Objection to SSD-82599709 at 153-157 Walker Street, North Sydney

This objection has been prepared in response to the proposed development at 153–157 Walker Street, North Sydney (SSD-82599709). The following matters are raised as key planning concerns and grounds for objection, based on identified non-compliances and inconsistencies with the North Sydney Local Environmental Plan 2013 (NSLEP 2013), the Apartment Design Guide (ADG), and amenity impacts of the proposed development.

Figure 3 South Elevation | Architectus

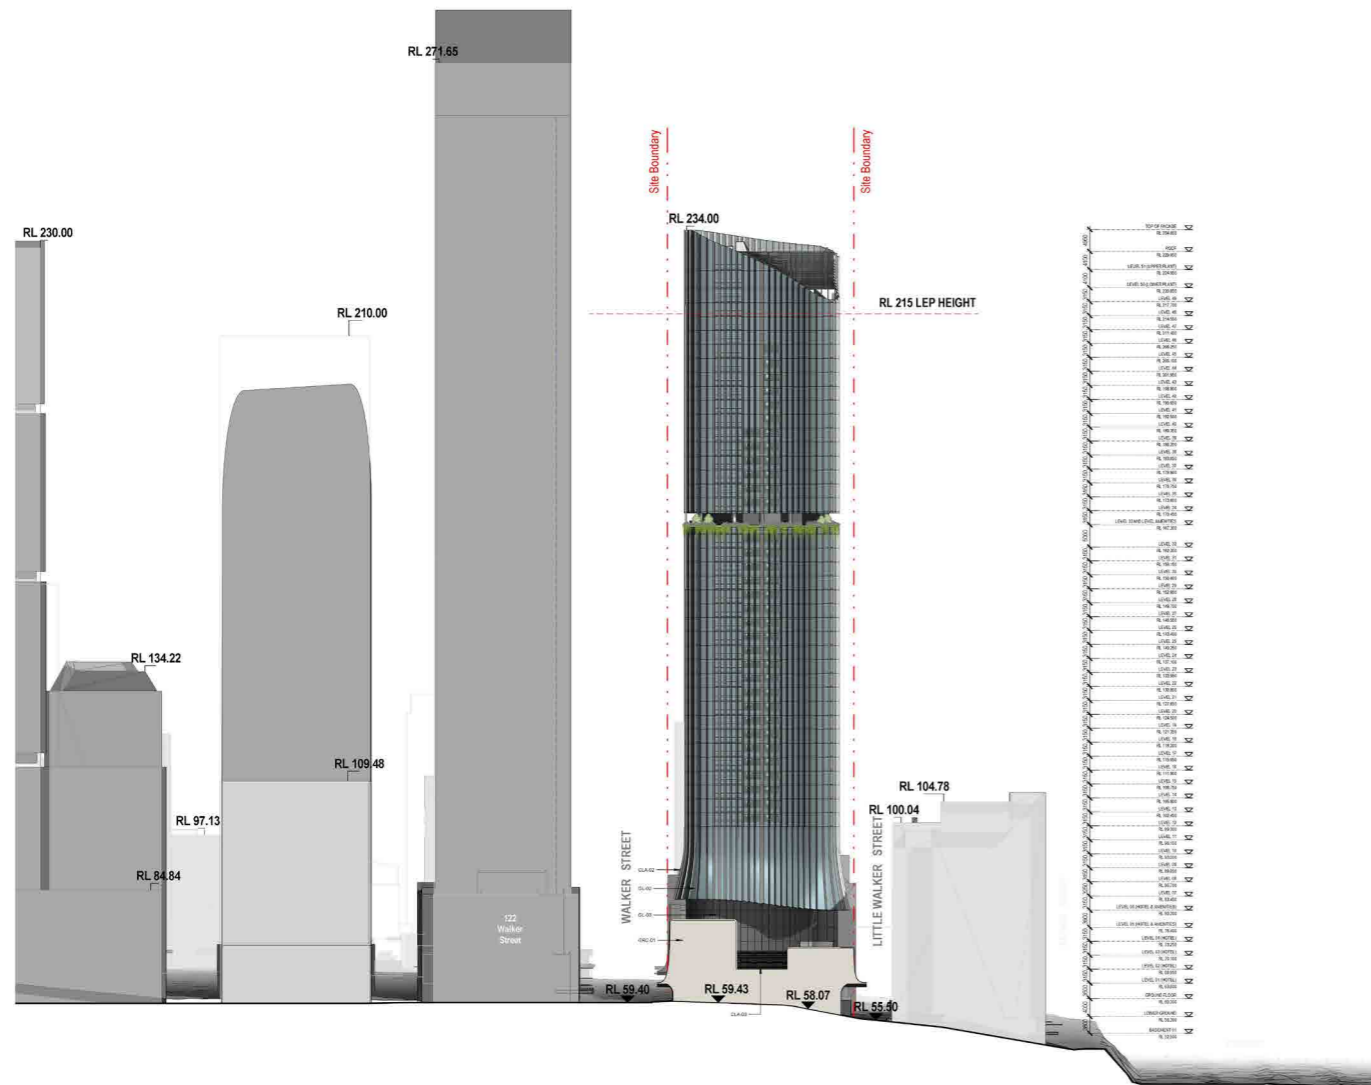
The proposal exhibits reduced tower separation from the adjoining development at 146 Arthur Street, particularly at the upper levels (Levels 15–22). The separation distances do not meet the ADG's minimum 24-metre requirement for buildings above nine storeys.

Rather than achieving compliance through appropriate setbacks, the design relies on façade louvres and privacy screens to manage overlooking and privacy conflicts. These devices are a poor substitute for spatial separation and often result in further reductions in solar access, exacerbating existing non-compliance with ADG solar access objectives.

The resulting configuration creates unacceptable privacy conflicts and amenity impacts on adjacent developments and fails to deliver the high-quality residential environment intended by the ADGs. Introducing a greater setback along Little Walker Street would not only reduce visual and privacy
